Title:
Figure 15-2: Construction Vehicle Emissions
Assessment Road Network

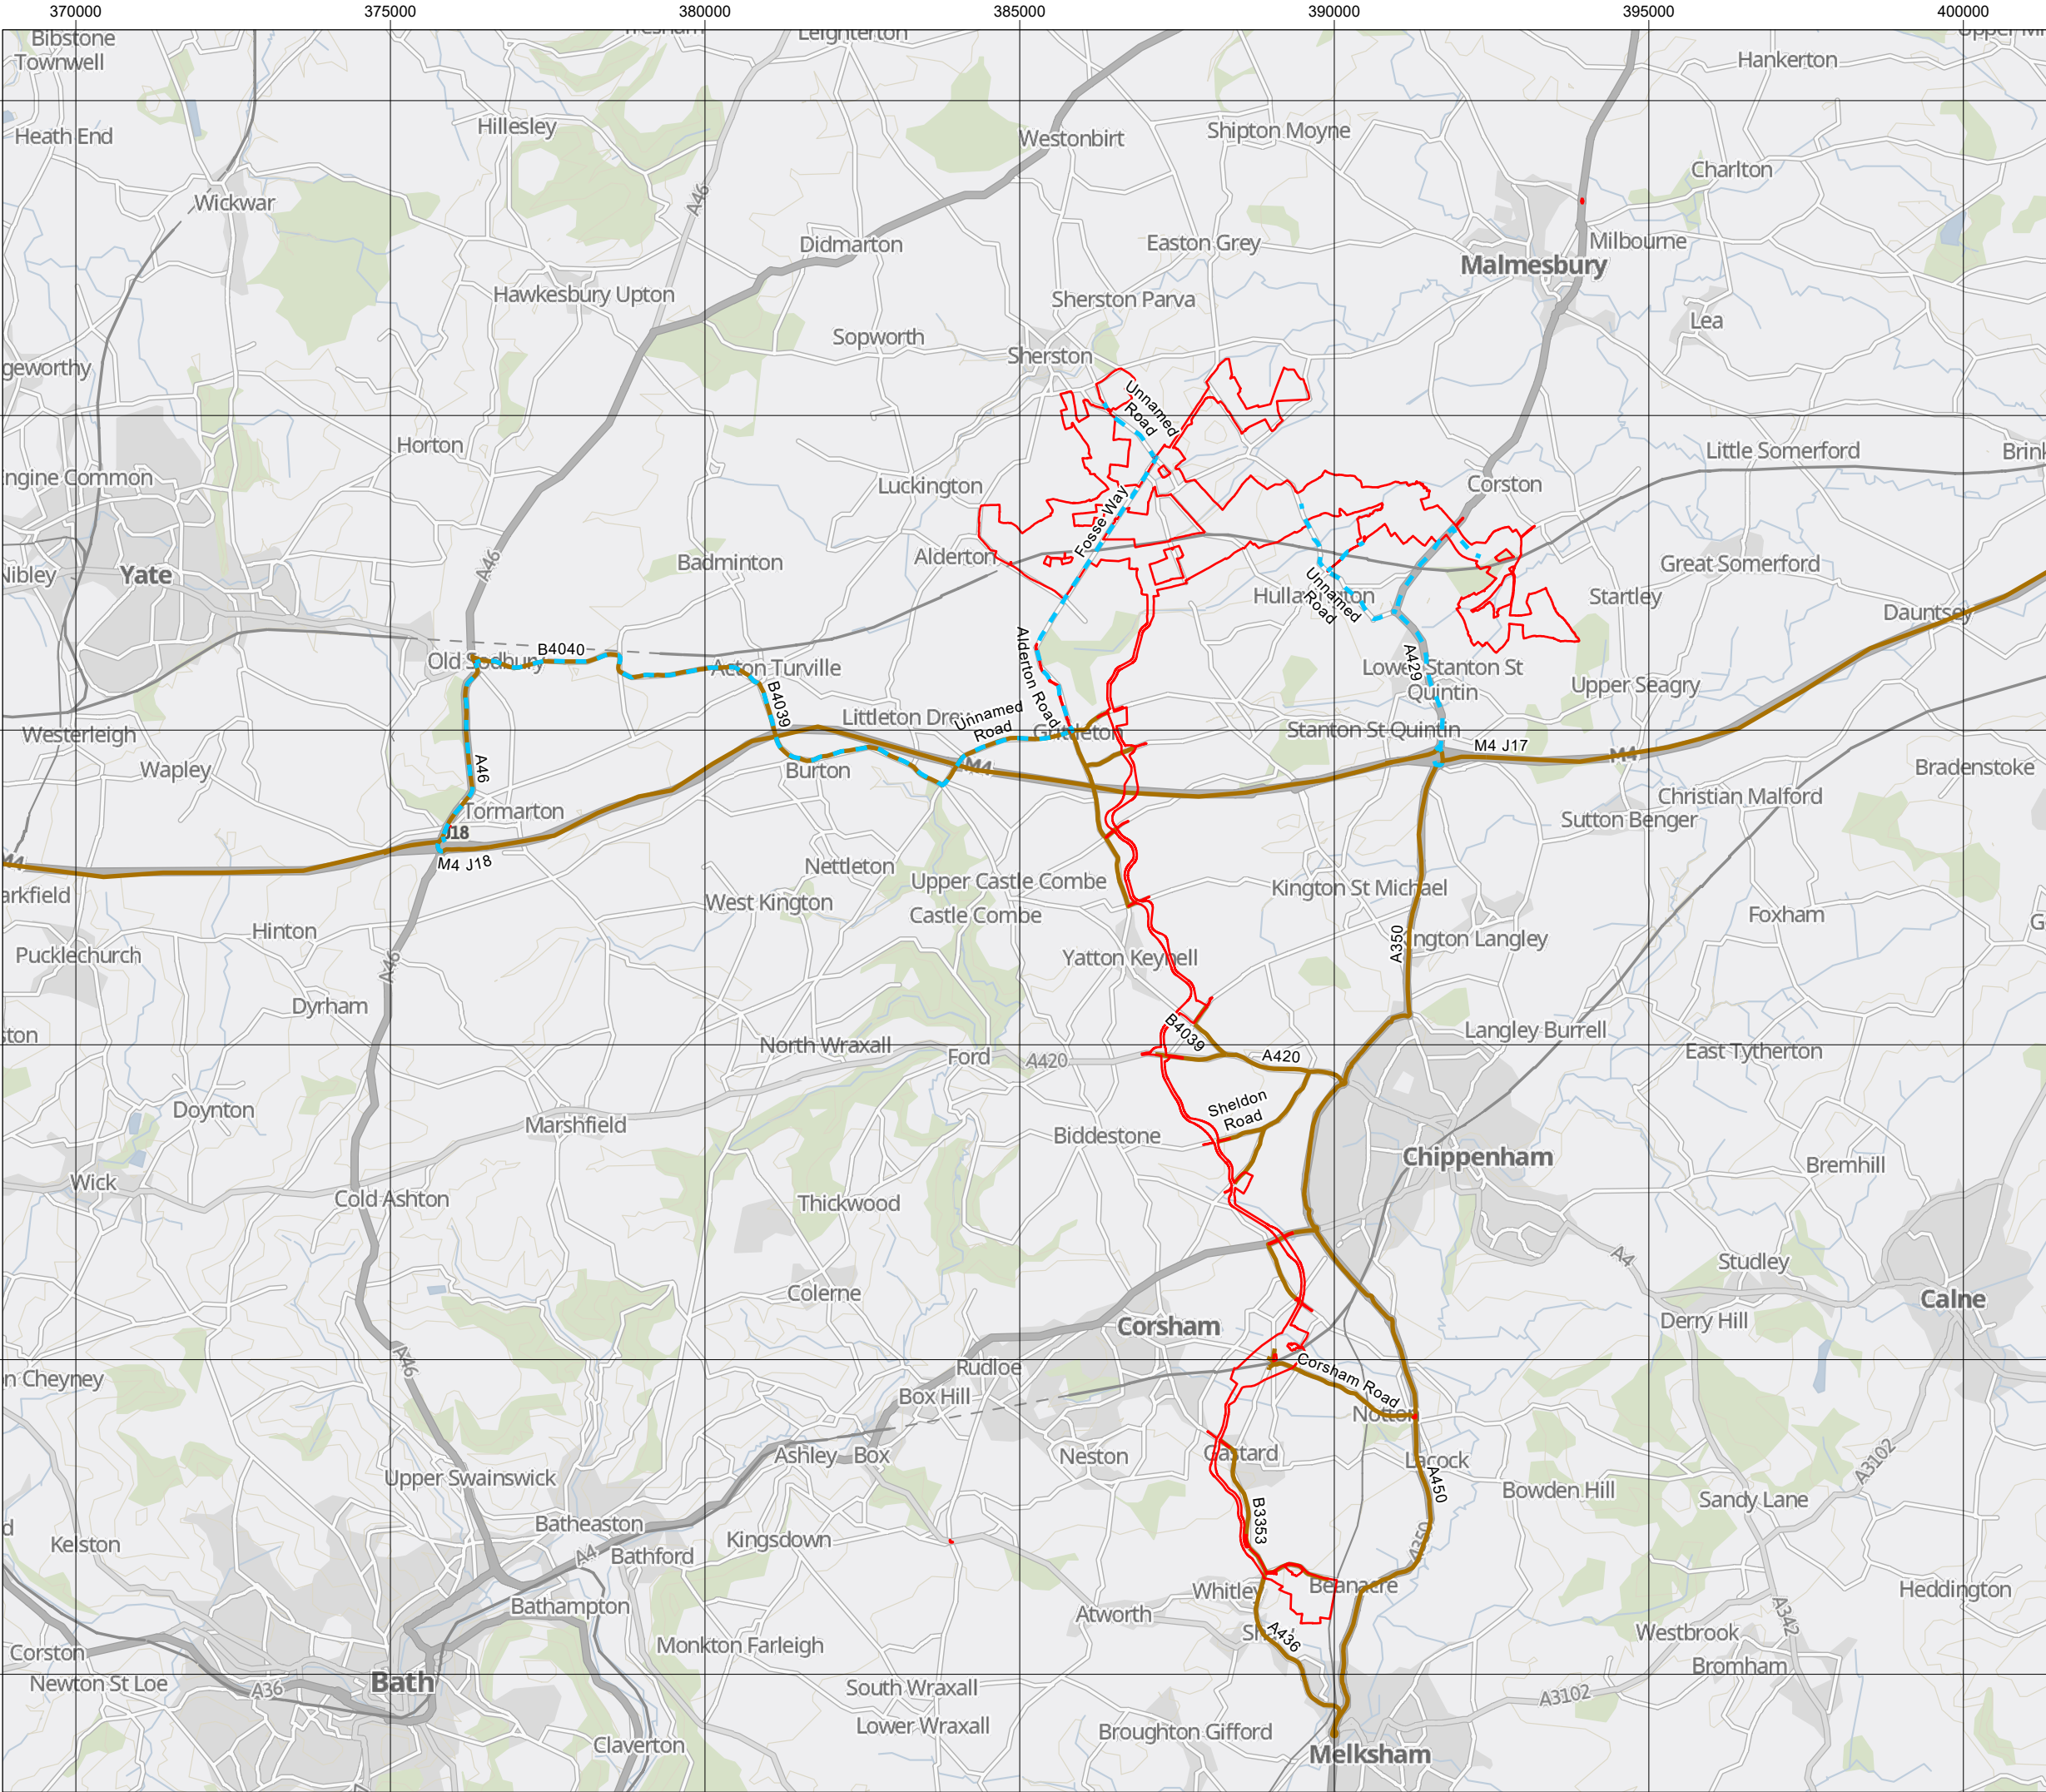
**Traffic Impact** - The applicant does not respond to our concerns as to the increased traffic on the rural lanes that link Sherston to Hullavington and Grittleton and the surrounding areas, nor acknowledge the risk to road users, particularly our aging population. Sherston has a high proportion of elderly residents because many choose to live their retirement in this area of outstanding natural beauty. They have raised concerns about having to face oncoming abnormally large vehicles and how they are going to navigate around them without an accident, particularly when reversing, which may be required for a significant distance. A number have raised fears that they will be too scared to drive locally during the period of construction, which, for some, will be their remaining lifetime.

Residents are also concerned that the drivers connected to the project construction will choose to use smaller lanes as "cut throughs" rather than stick to the designated construction routes. The applicant needs to clarify what measures they will put in place to ensure that drivers of vehicles during construction, operation and decommission will stick to the defined routes and how this will be monitored/managed.

Our residents also worry as to how they will access the towns of Malmesbury and Chippenham (and its train station) as well as the M4 and M5 when the single track roads are blocked or hindered by transport of AILs. The inevitable increase in traffic both through the town and on the smaller lanes, combined with navigating around AILs on the larger ones, will we fear will lead to an increase in accidents. The applicant has not addressed these issues in their response.
